**WEST SUSSEX COUNTY COUNCIL
STRATEGIC PLANNING CONSULTATION**

SUBJECT: BR/45/17/PL - Variation of condition 2 imposed under BR/270/16/PL relating to approved plans.

Villa Maria, Campbell Road, Bognor Regis, West Sussex, PO21 1NW

Title:-
Proposed Second Floor Plan

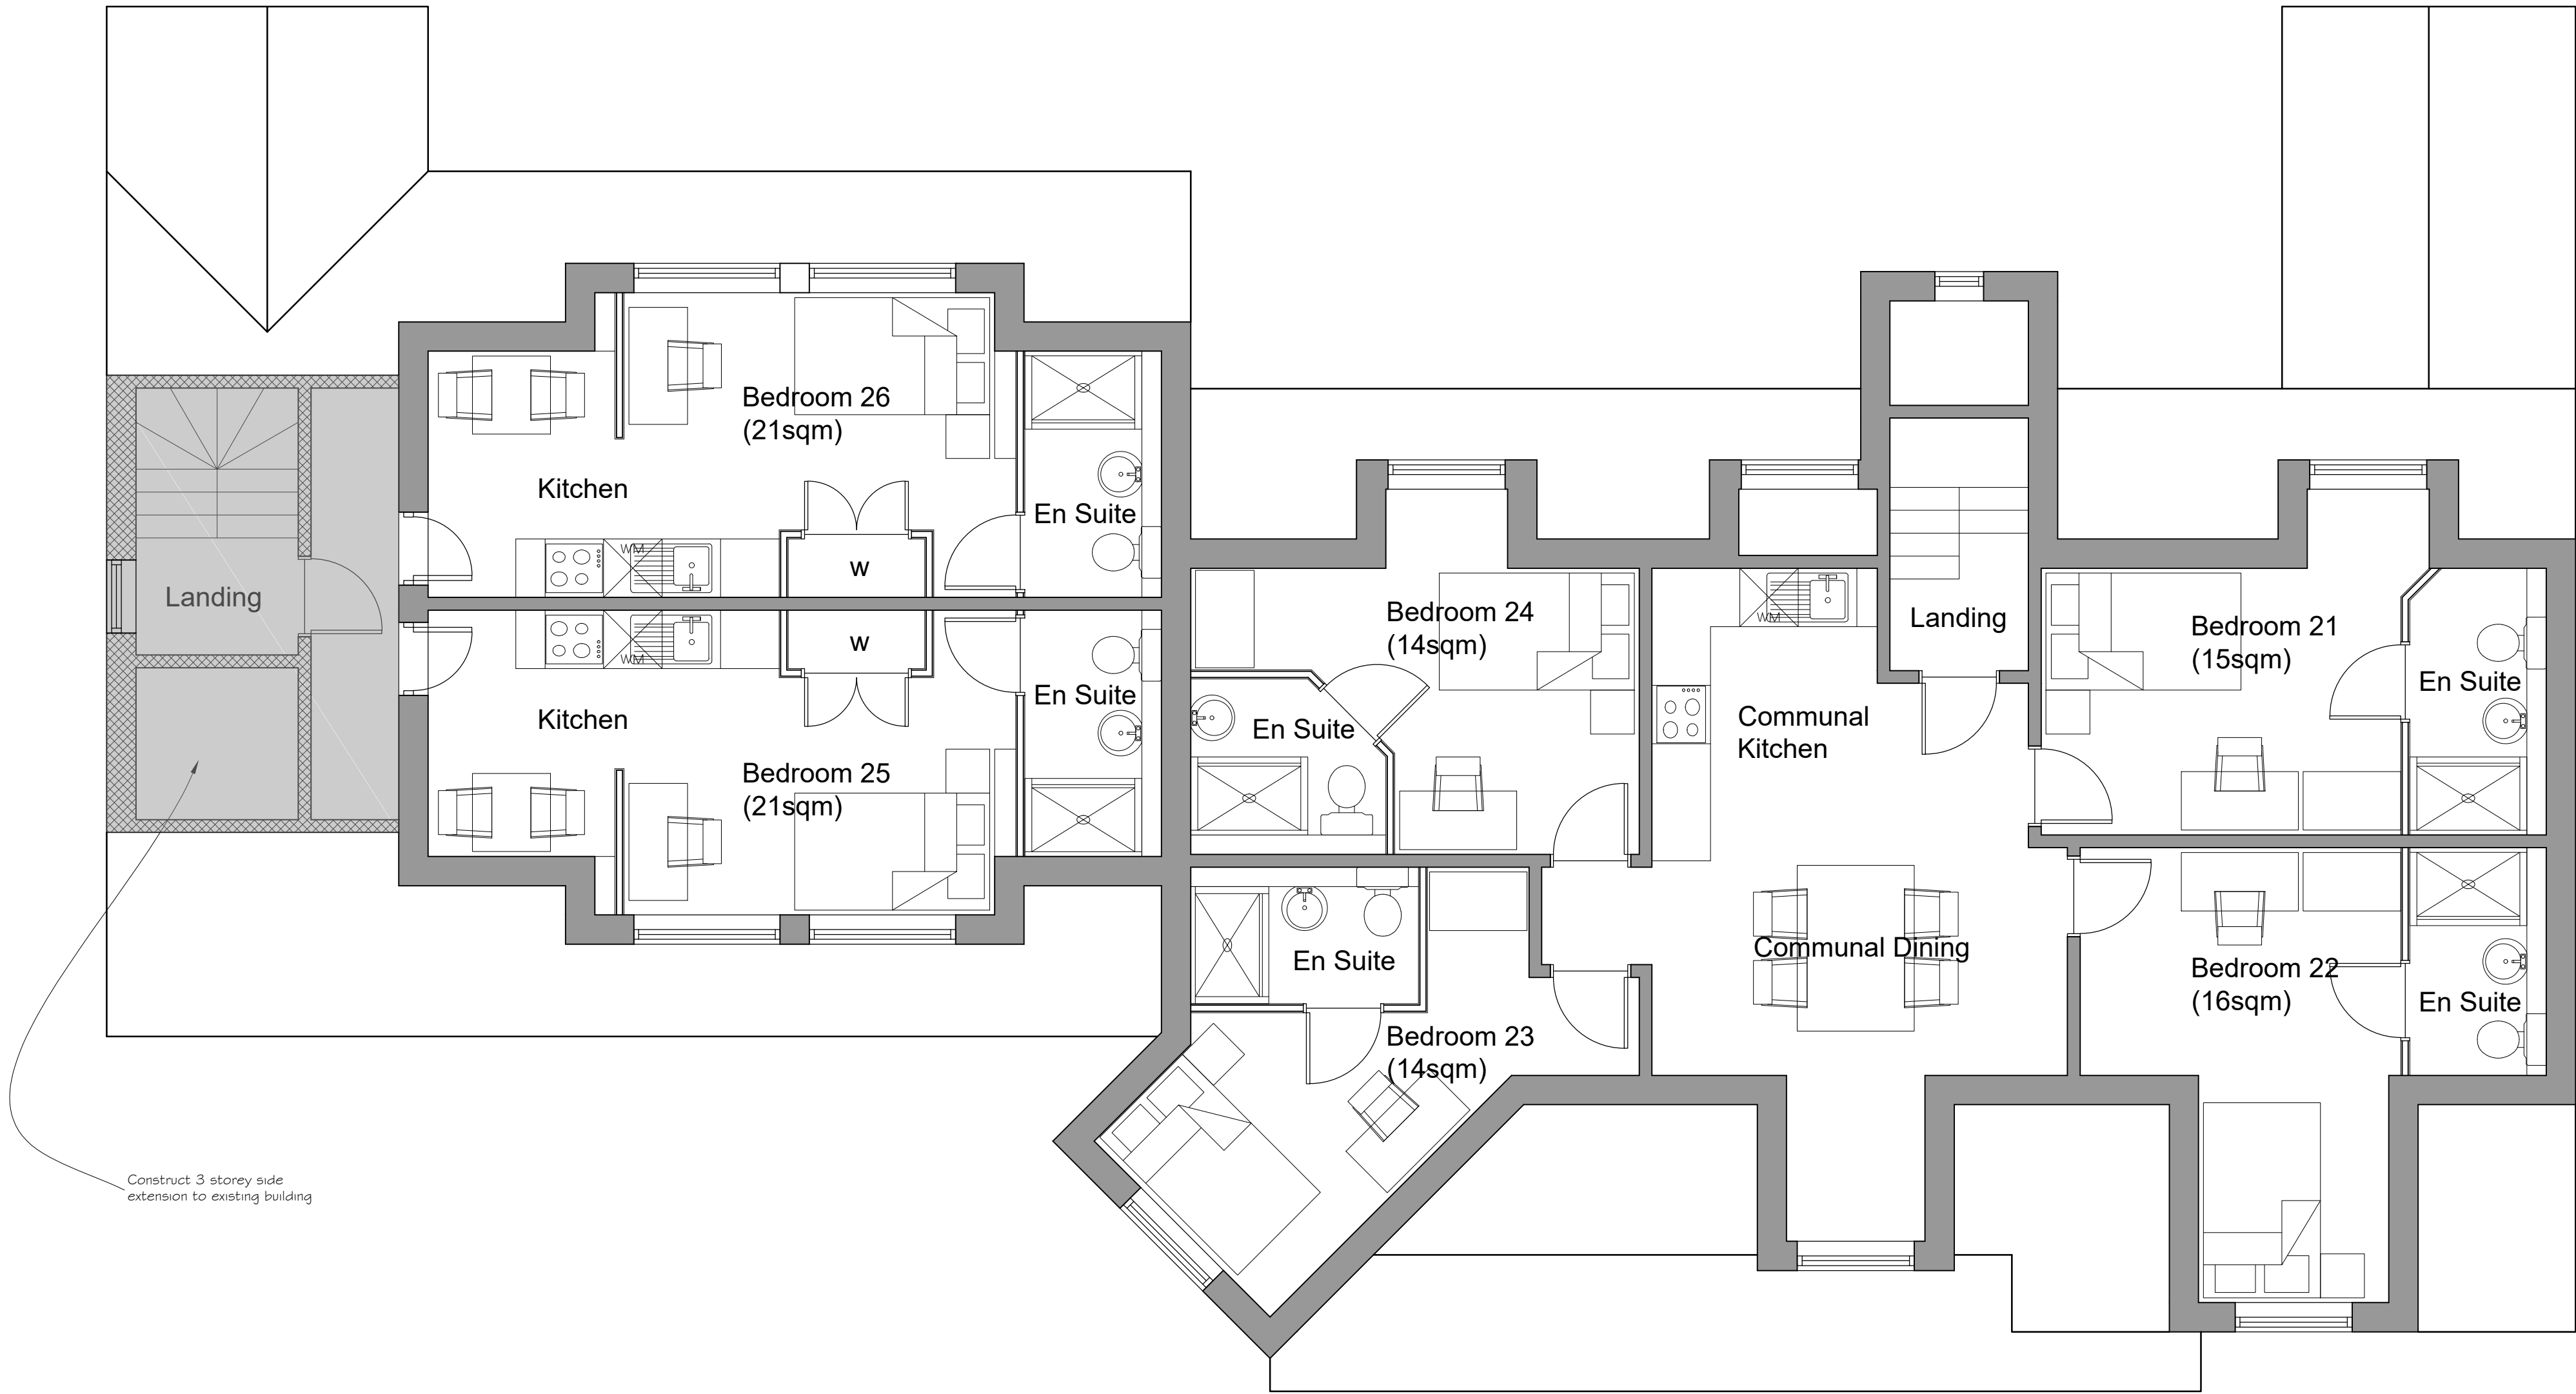
The proposal to change the layout to the 2nd floor of the previously approved planning consent for student accommodation has been considered by WSCC as the Local Highway Authority. No objection is raised to the changes proposed. These are to create a 4 bed flat with en-suite bathrooms in each room, with a communal kitchen and eating area.

These changes will create 1 additional bedroom increasing the total number of students accommodated from 25 to 26. No parking will be provided and as the site will be occupied by students it is unlikely they will have a car. Should students need a car parking space they will need to register for a residents permit holder to park outside on Campbell Road. There are spaces free on the opposite side with a 2 hour parking limit which can provide some visitor parking, or parking for moving in and out during the academic year.
